Date: 10-Jul-2026
Our Ref: 2026/90919

**PRIOR APPROVAL FOR ALTERATIONS TO BRIDGE MVL3/48
OFF, GRANGE STREET, MARSDEN, HUDDERSFIELD, HD7 6AJ
APPLICATION NO: 2026/90919**

Drawing Title: **Prior Approval - MVL3/48 Grange Street - Existing and Proposed Elevations and Sections**

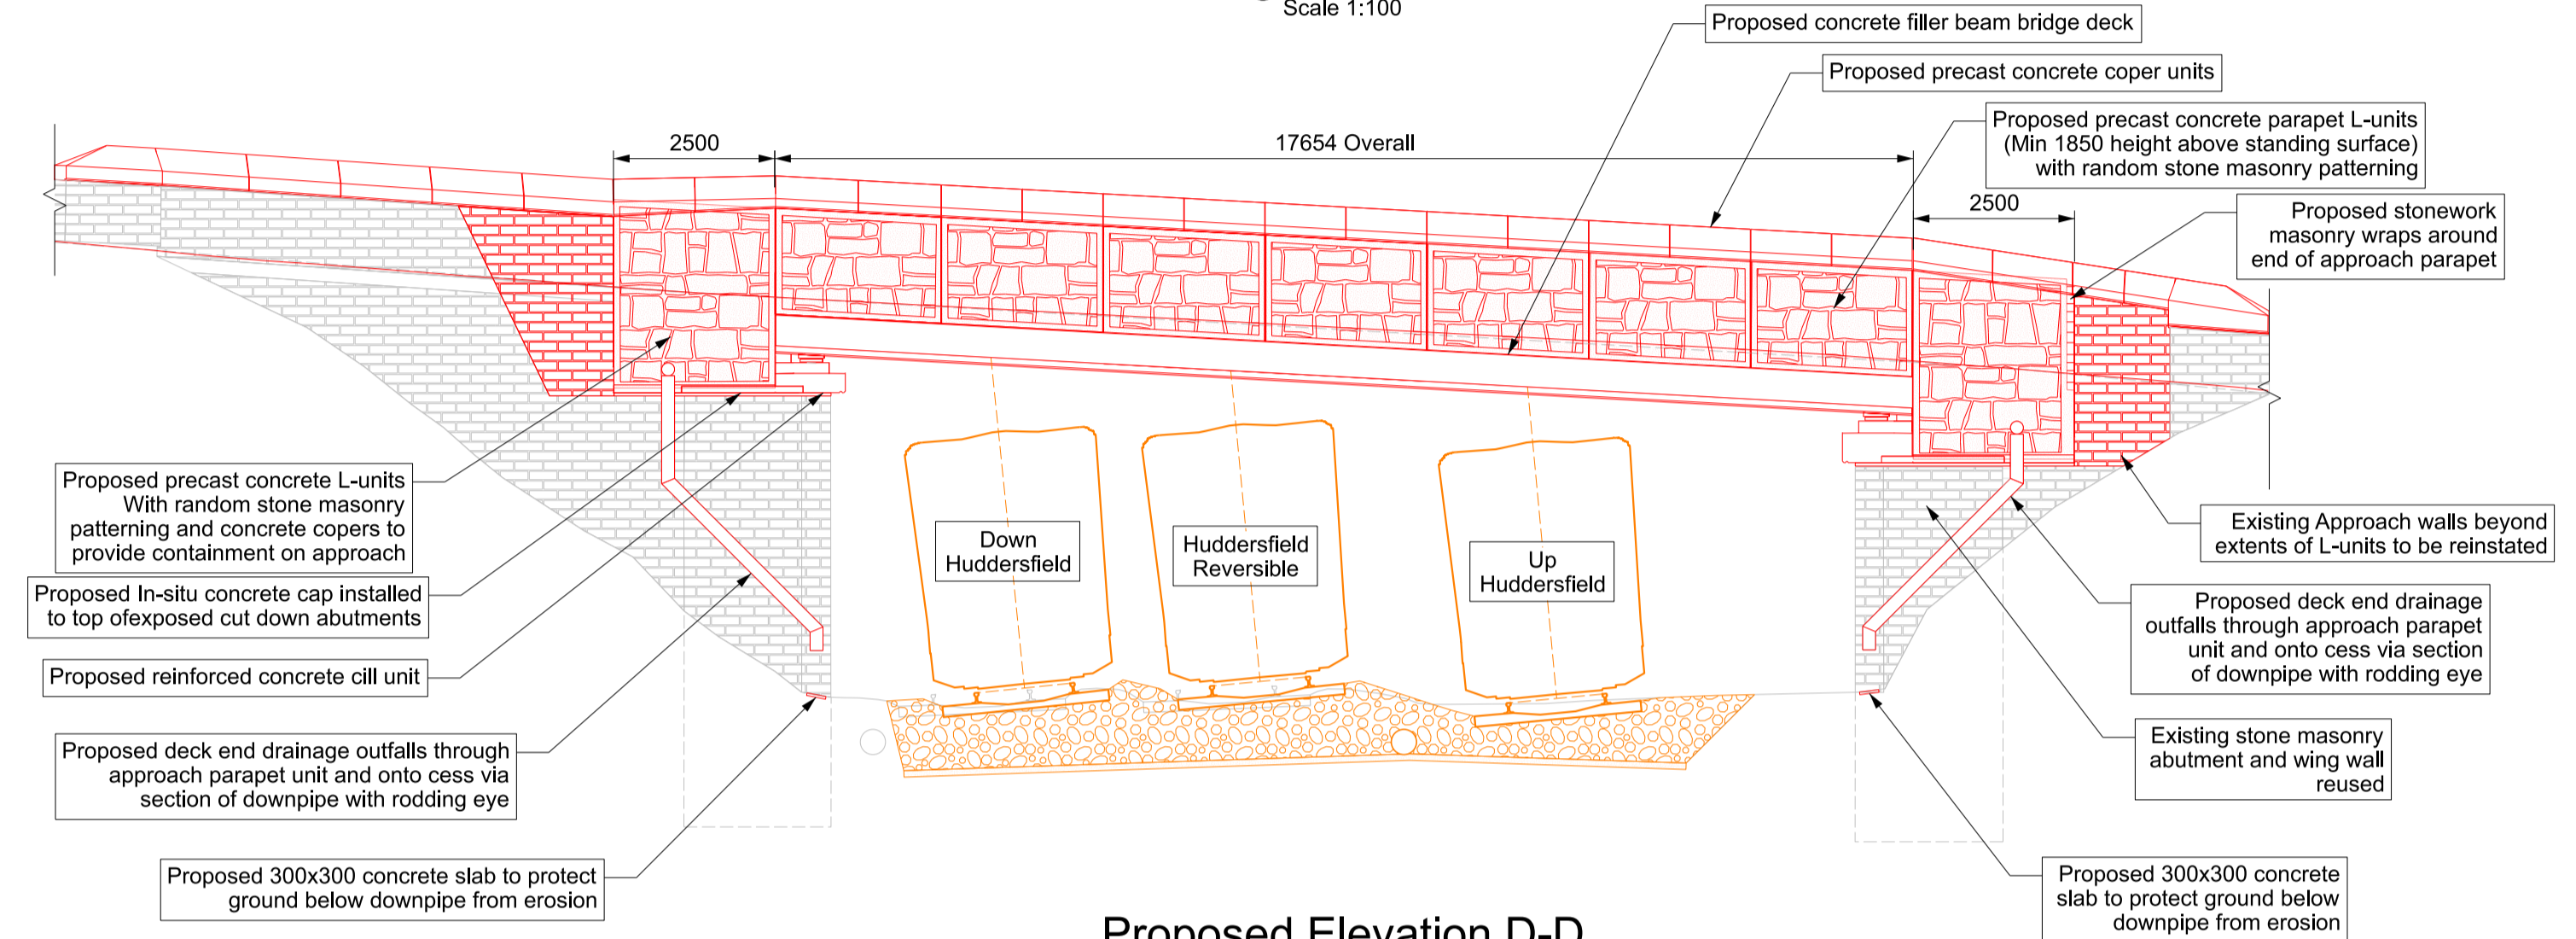
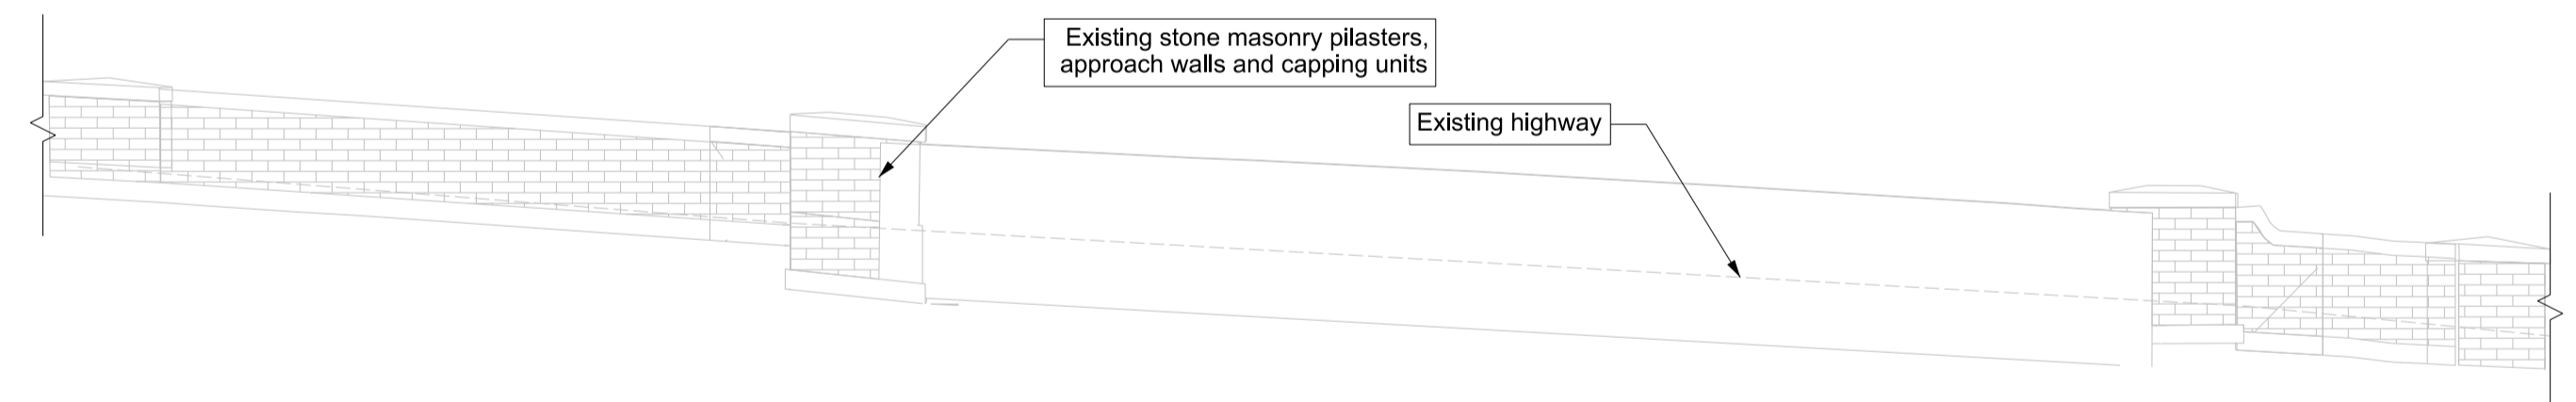
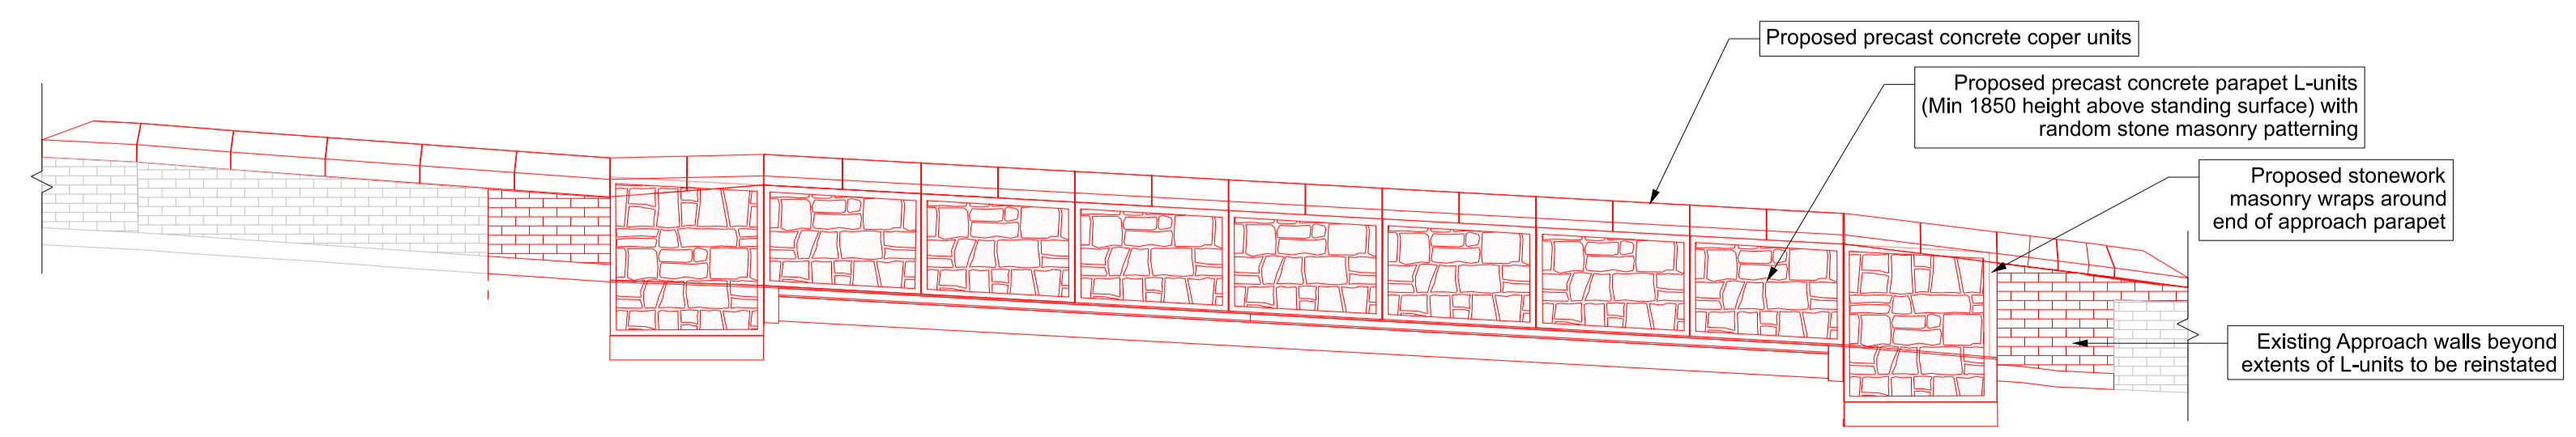
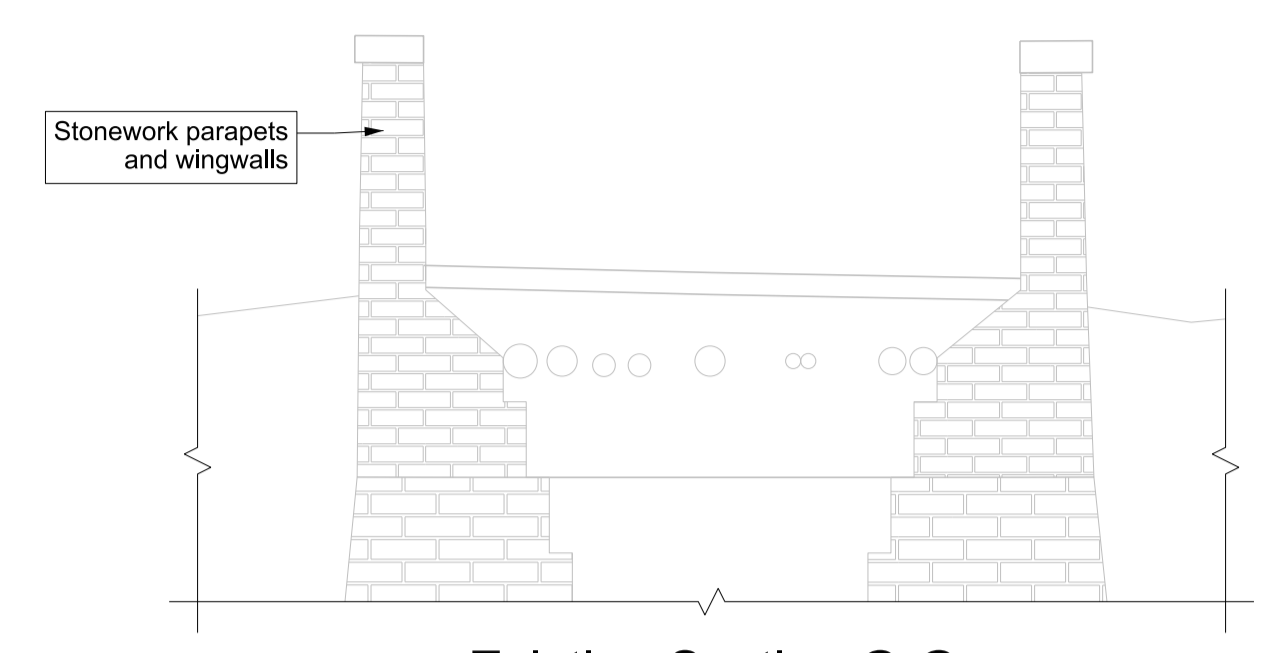
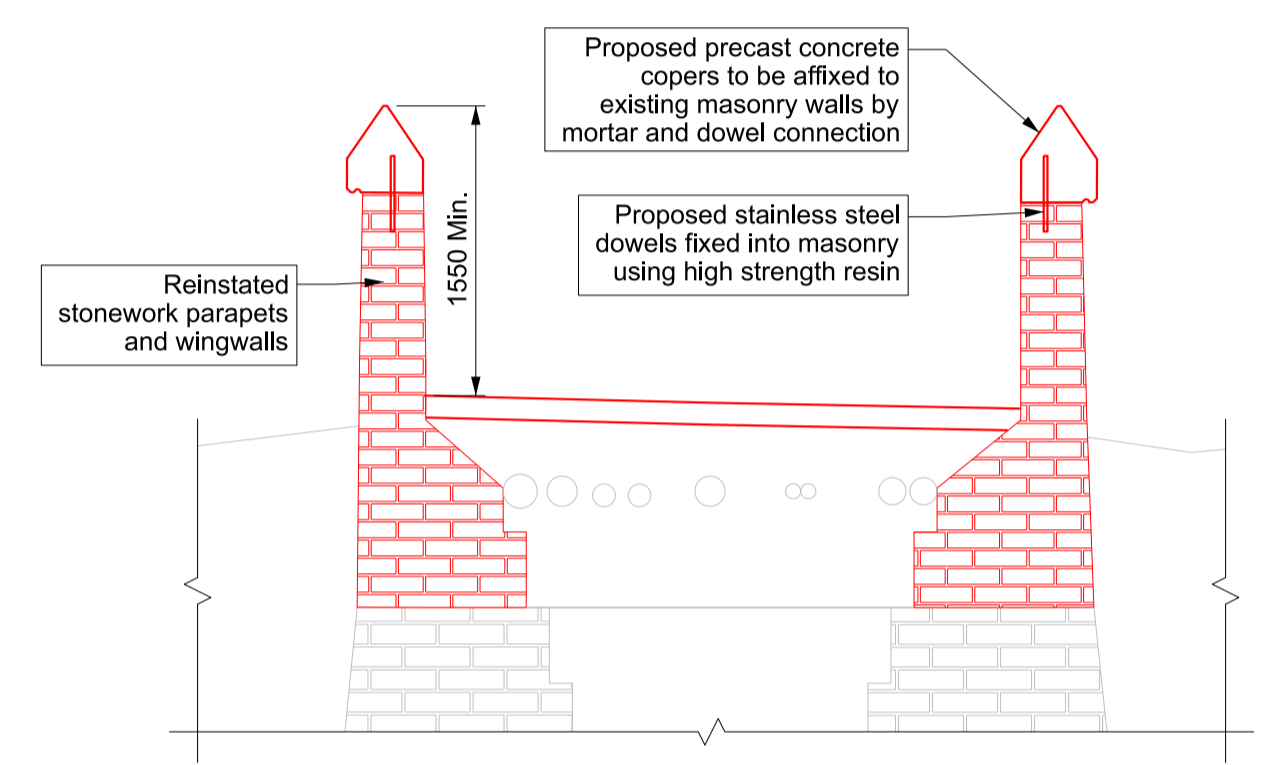
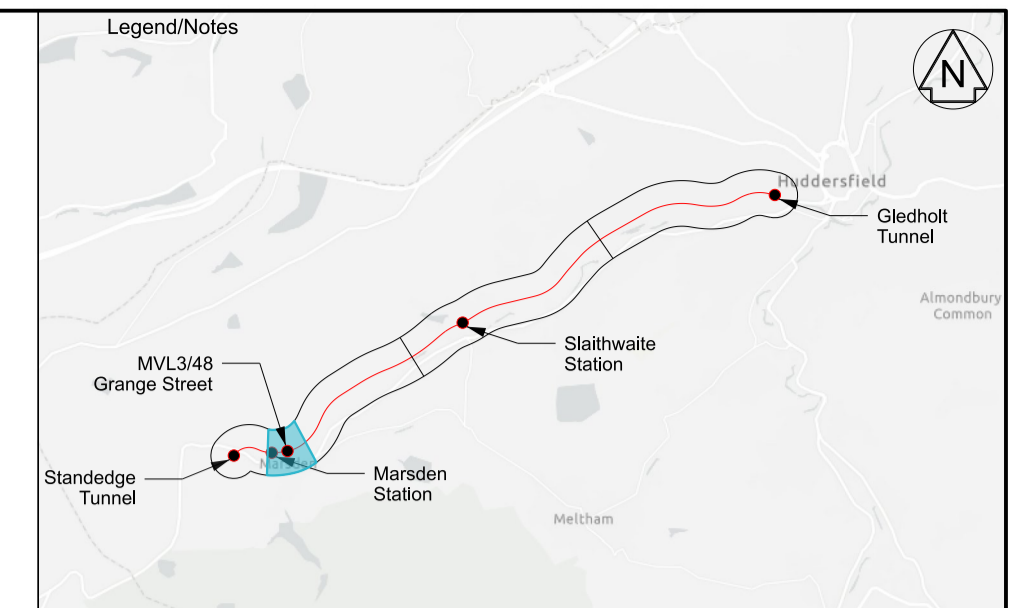
1. Notwithstanding the submitted plans, a sample of the parapet finish[es] shall be submitted to and approved by the Local Planning Authority, prior to their installation. The external treatment of the parapet finish[es] shall reflect the retained stonework of the bridge in terms of colour, texture, finish and coursing.
Reason: In the interests of visual amenity and the conservation of the Historic Environment and to accord with Policies LP24 and LP35 of the Kirklees Local Plan.
